Application for a non-material amendment following a grant of planning permission.
 Town and Country Planning Act 1990

DEMOLITION OF EXISTING SINGLE STOREY DOUBLE GARAGE AND THE CONSTRUCTION OF TWO-STOREY FRONT EXTENSIONS, INCLUDING ADDITIONAL DORMER WINDOWS.....

21/00021/FUL

RELOCATE PREVIOUSLY CONSENTED "VELUX" ROOF LIGHTS FROM 1X BEDROOM & 2X EN SUITE TO 2X BEDROOM & 1X EN SUITE. HEIGHT OF ROOF LIGHTS AND SIZE OF UNITS TO REMAIN AS PREVIOUSLY CONSENTED. THE EFFECT WILL BE TO MOVE ONE ROOF LIGHT c 2m FURTHER ALONG ROOF AWAY FROM OUR NEIGHBOUR'S PROPERTY

22 Main Street, Kinoulton - Proposed Rear and Side 2 Elevation

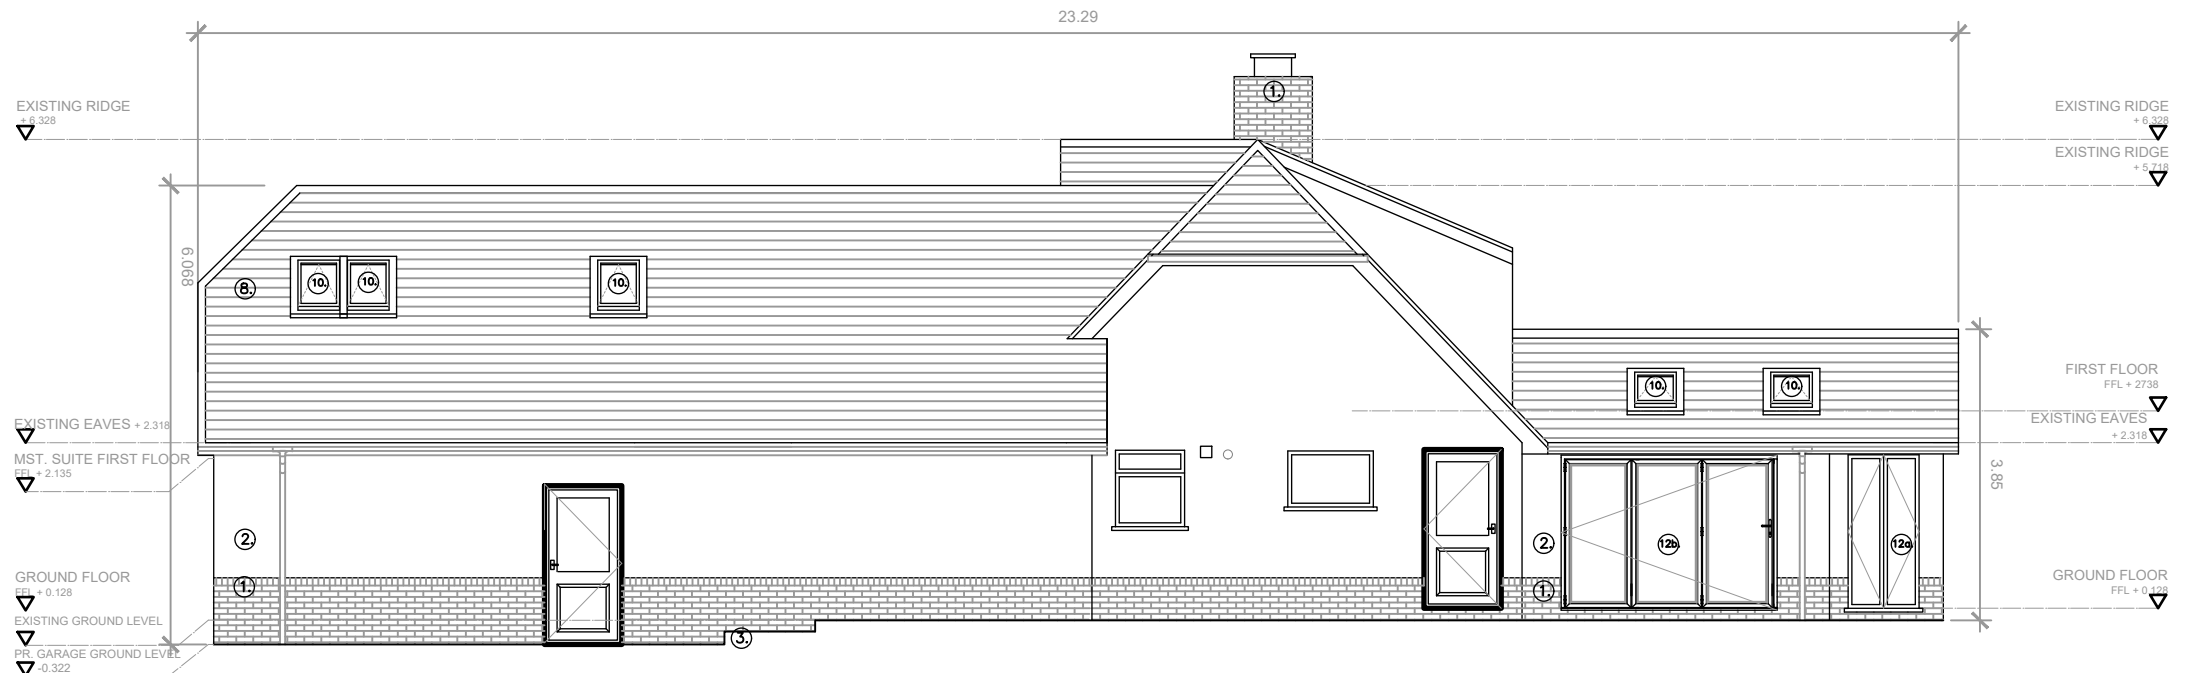
103 E & 110 D

001_02-D FIRST FLOOR PLAN & 002_05-D PROPOSED SIDE ELEVATION
